**KIRKLEES METROPOLITAN COUNCIL
INVESTMENT & REGENERATION SERVICE**

Reference No: 2020/62/90133/E

Site Address: 1, Chapel Royd, Emley, Huddersfield, HD8 9GN

Description: Erection of extension to garage and front and rear dormer windows

ground floor level

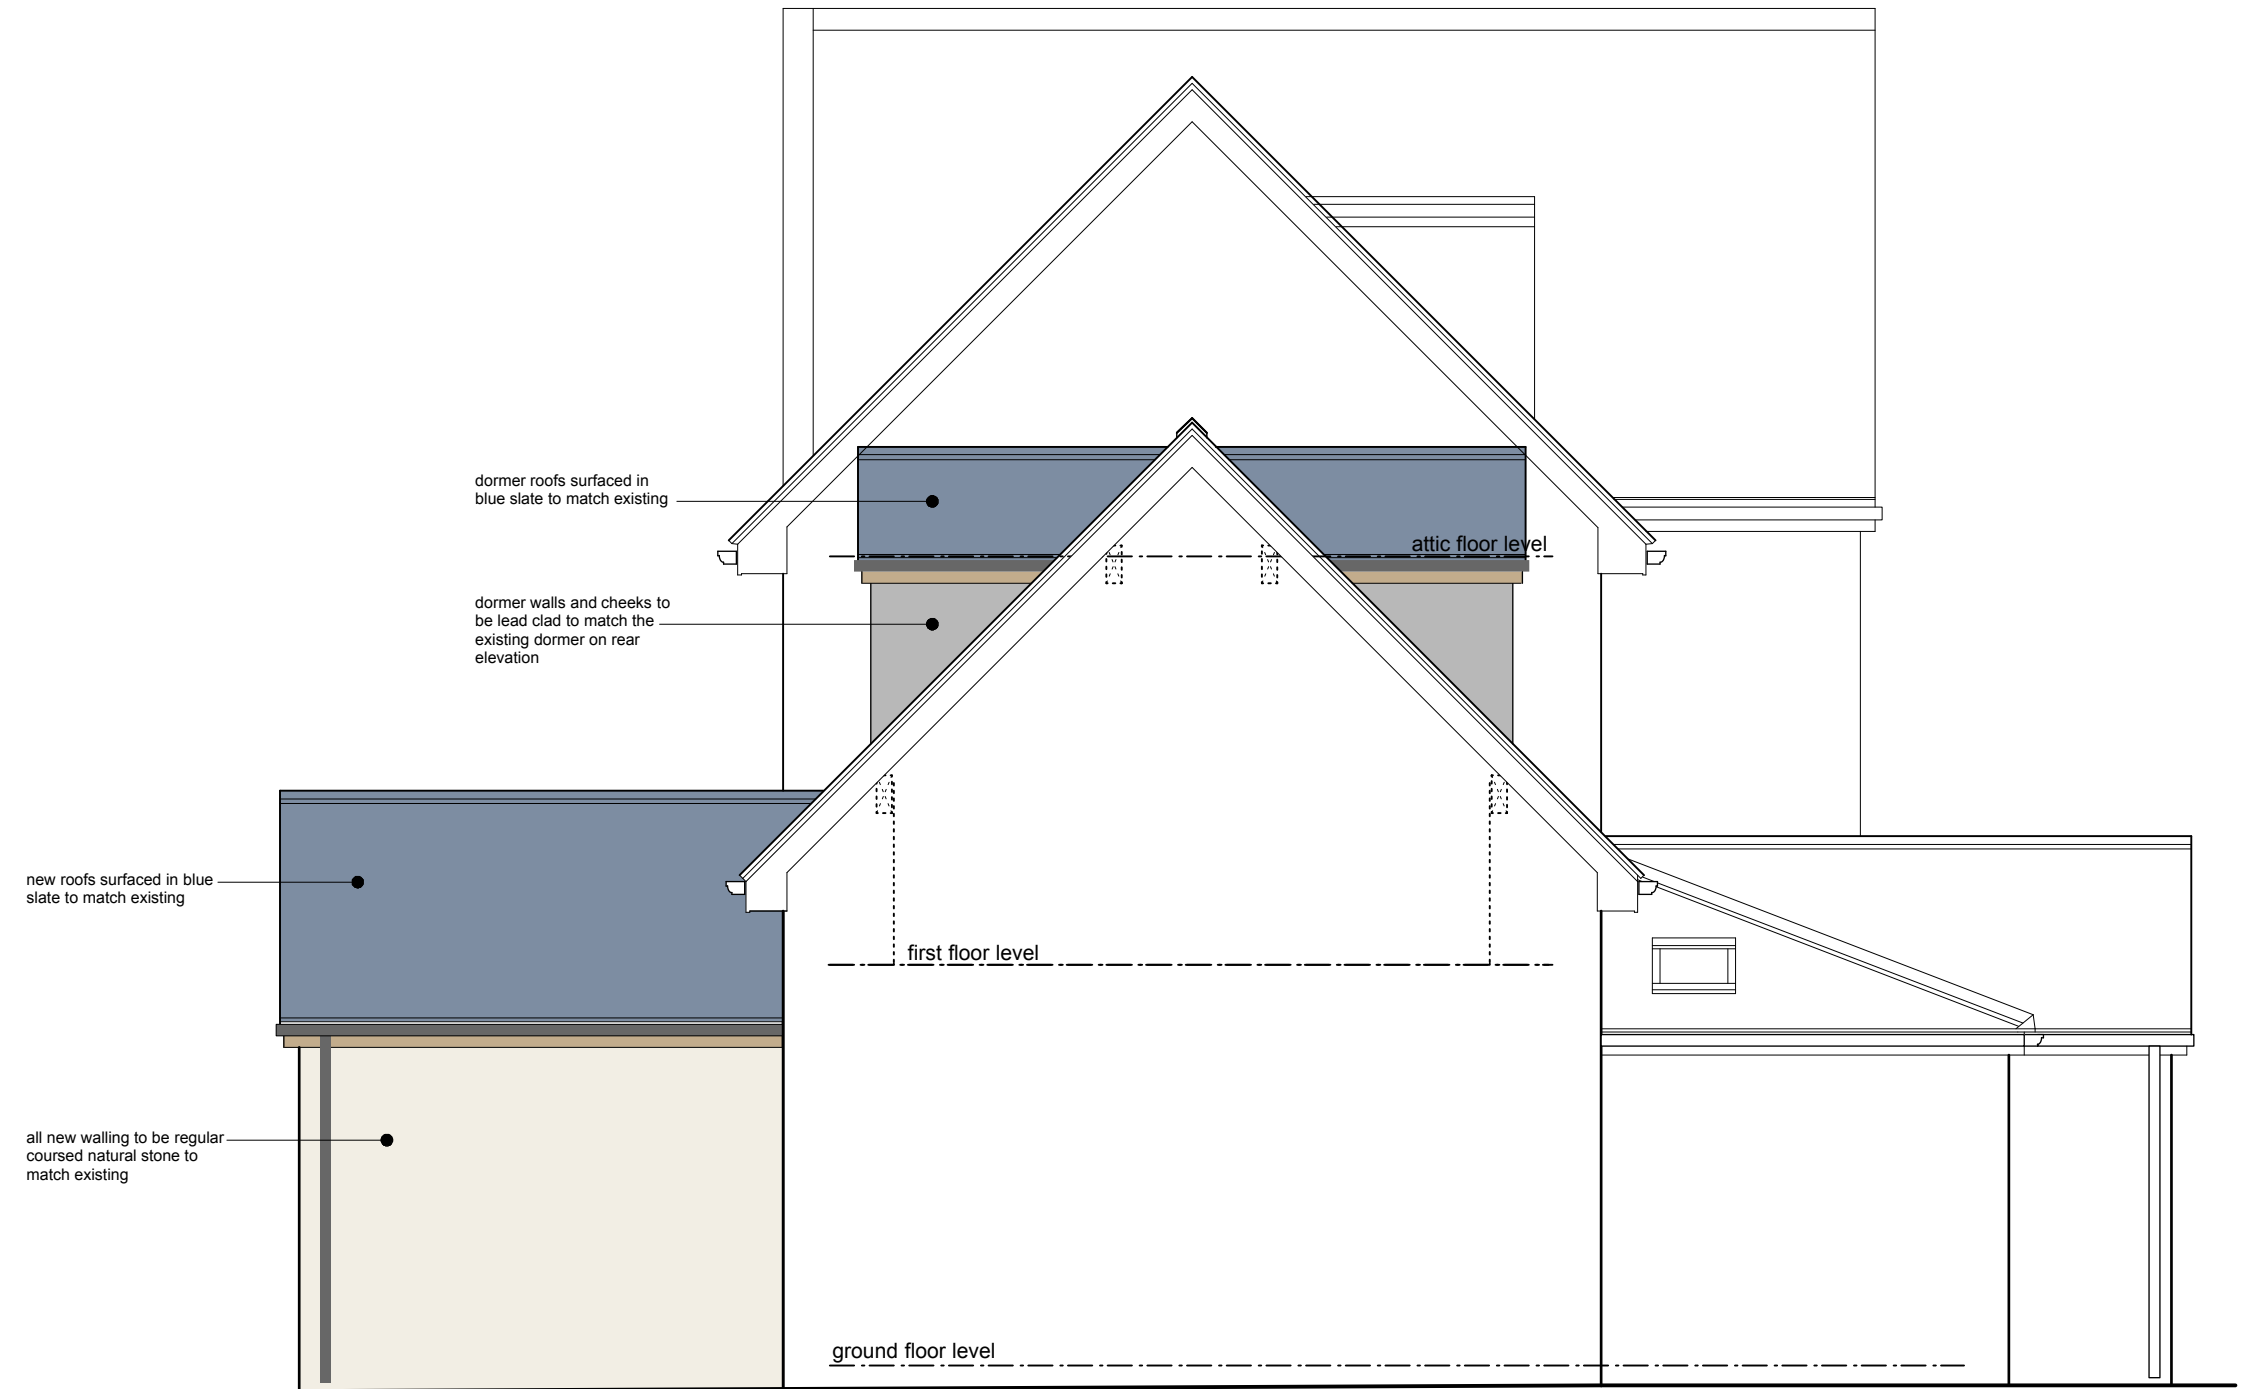
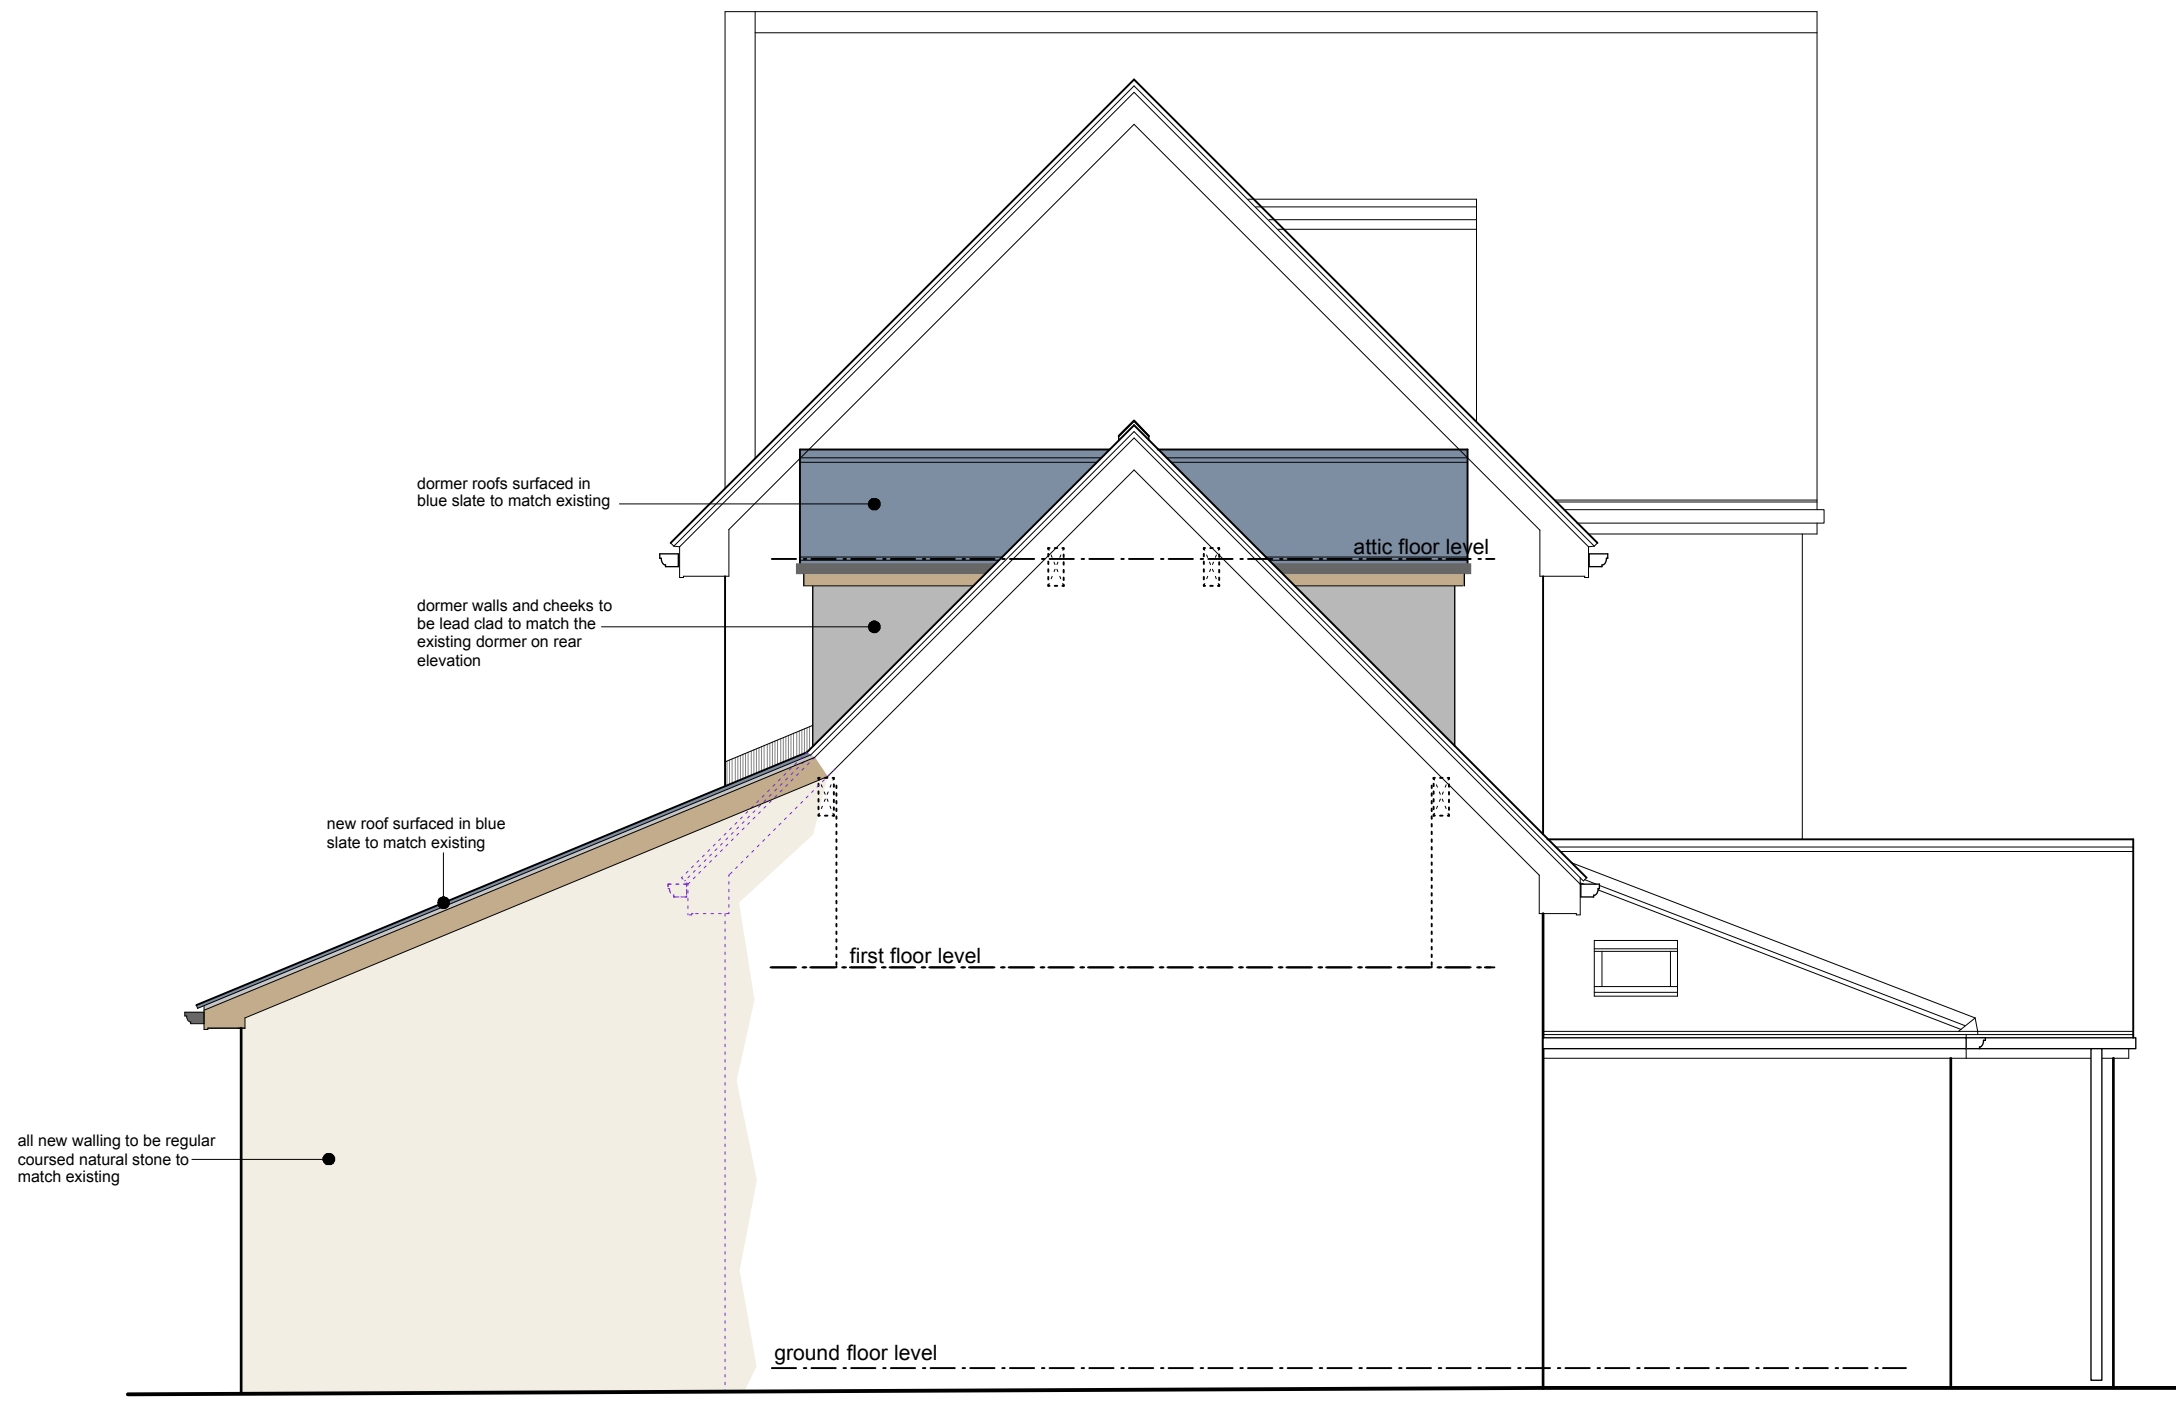
Officers raised concern with the agent regarding the relationship between the garage extension and the host property and suggested that this element be removed from the proposal. The agent submitted amended plans replacing the original gable roof form with a catslide roof form. The amended plans are considered to, on balance, address officers concerns.

Whilst the amended plans would result in a small increase in the maximum height of the garage extension, as a result of the introduction of a catslide roof form, it is considered that the overall impact on the adjacent properties would be reduced. As a result, and due to the nature of the amendments which replace the proposed roof form of the garage extension, it was not considered necessary to advertise the amended plans in this instance.
